Householder Application for Planning Permission for works or extension to a dwelling

Proposed rear extension, rear dormer and other alterations to an existing dwelling

RV/2022/ENQ/00040

SHEET: EXISTING AND  
PROPOSED  
ELEVATIONS

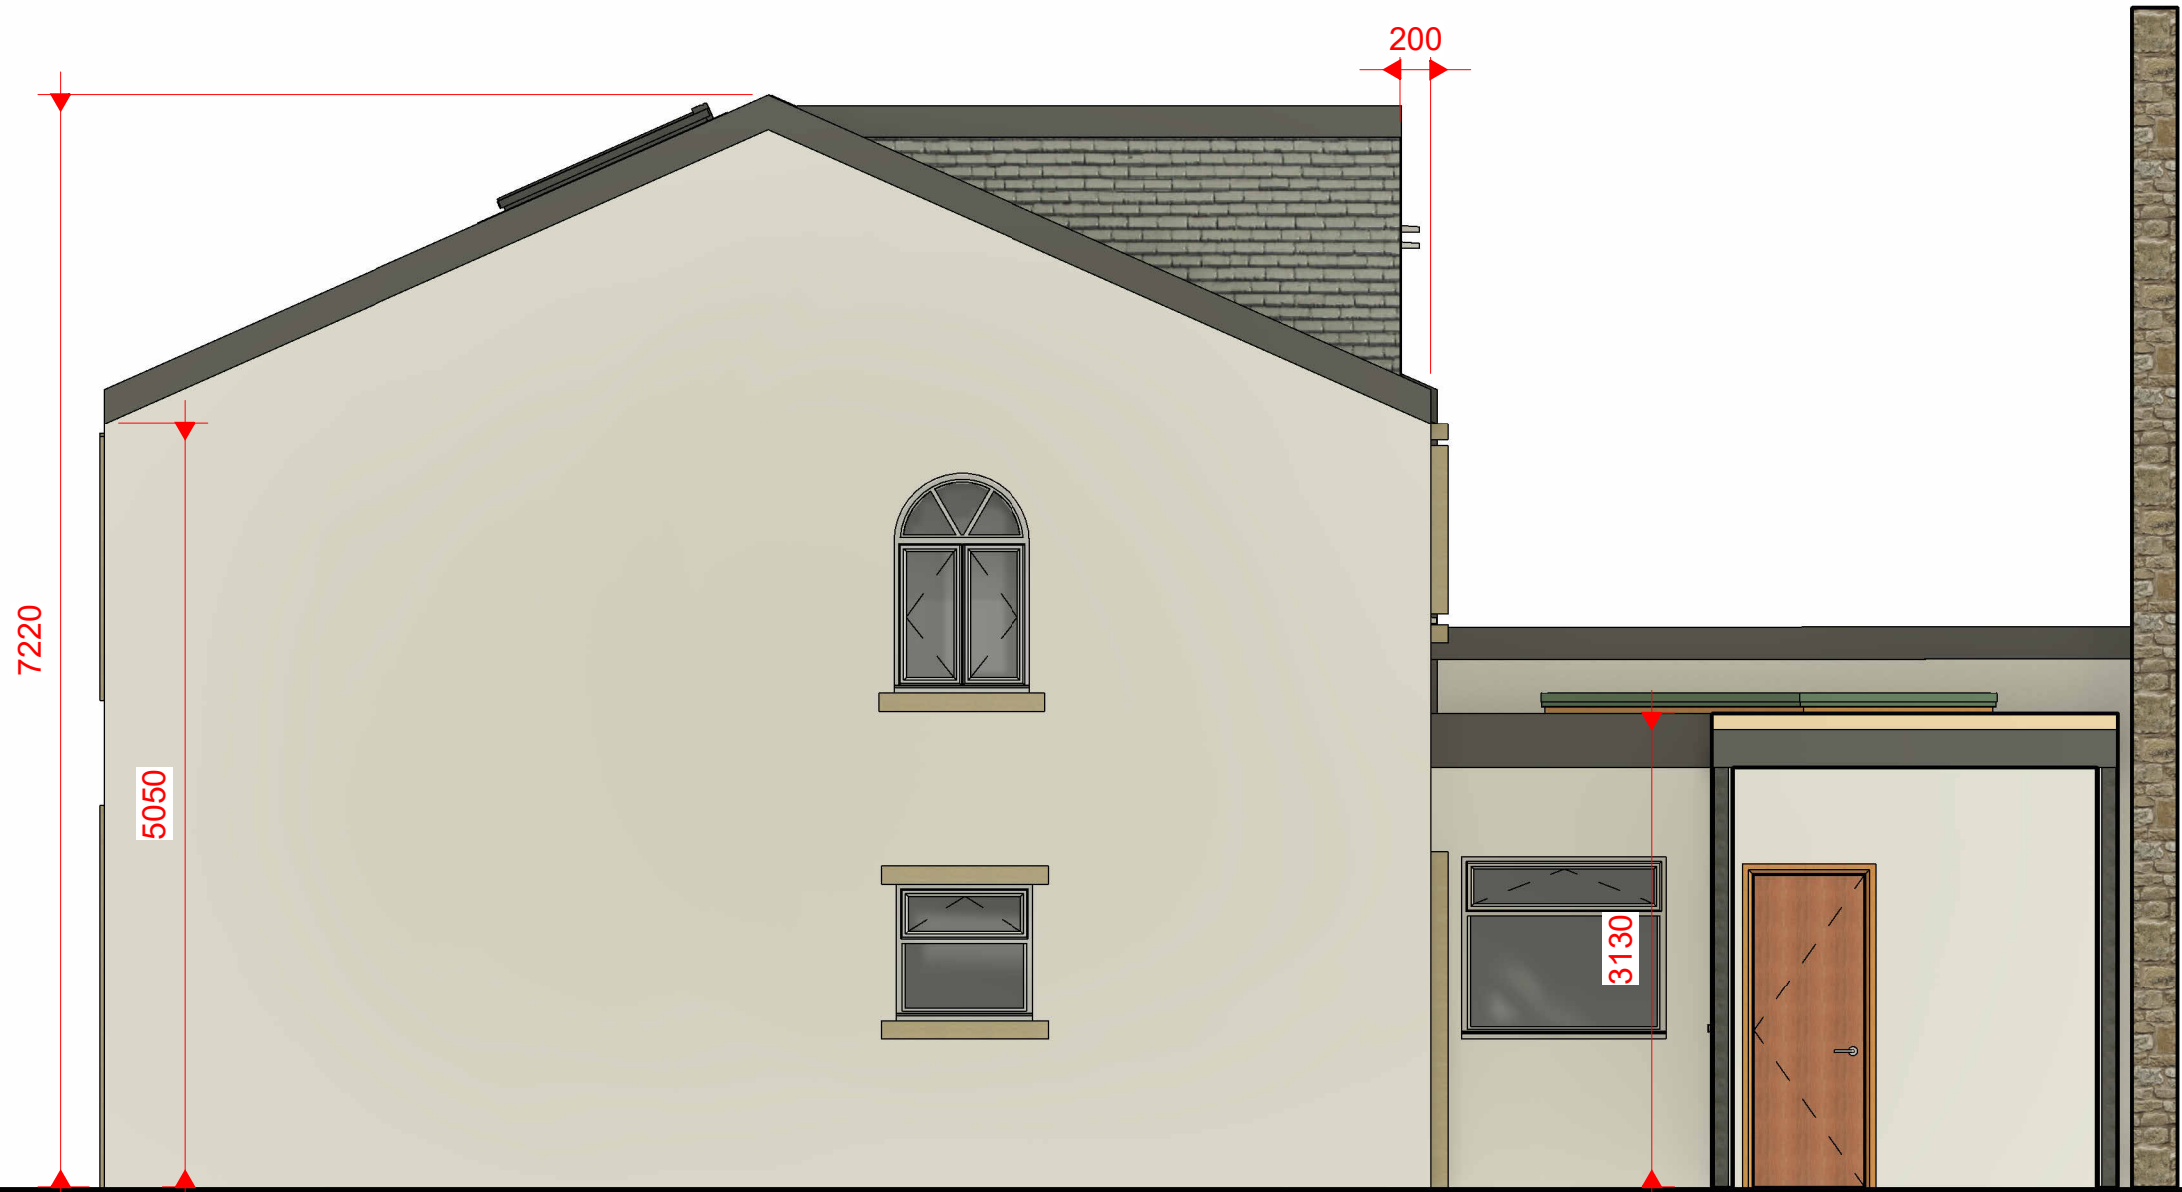
As conveyed in my earlier correspondence, I do not consider that the rear 'box dormer' could be supported insofar that it would appear as an anomalous and discordant addition into the roofscape, significantly undermining the character and visual amenities of the designated Clitheroe Conservation Area. I further consider that the addition would significantly undermine and harm the inherent character of the existing building which is an identified Building of Townscape Merit.

In relation to the rear extension. Given there may be limited views afforded from the public realm of the structure and that it will be read in conjunction, from the south, with a primarily stone-faced elevation, I consider that this element of the proposal may benefit from being faced in natural stone also, however I am mindful that the side and rear elevations of the dwelling are currently rendered.

In terms of the architectural language of the extension, the language is relatively austere and simple which assist in the extension appearing subordinate to the main building, however I do consider the extension would benefit from a more sympathetic roof form to ensure its visual compatibility with the existing dwelling and that of the wider area.

As such, taking account of the above matters it is the opinion of the authority that the proposal could not be supported insofar that it would result in the introduction of an incongruous, anomalous, and discordant element into the roofscape that would be of significant detriment to the character and visual amenities of the area and the inherent character of the host dwelling.
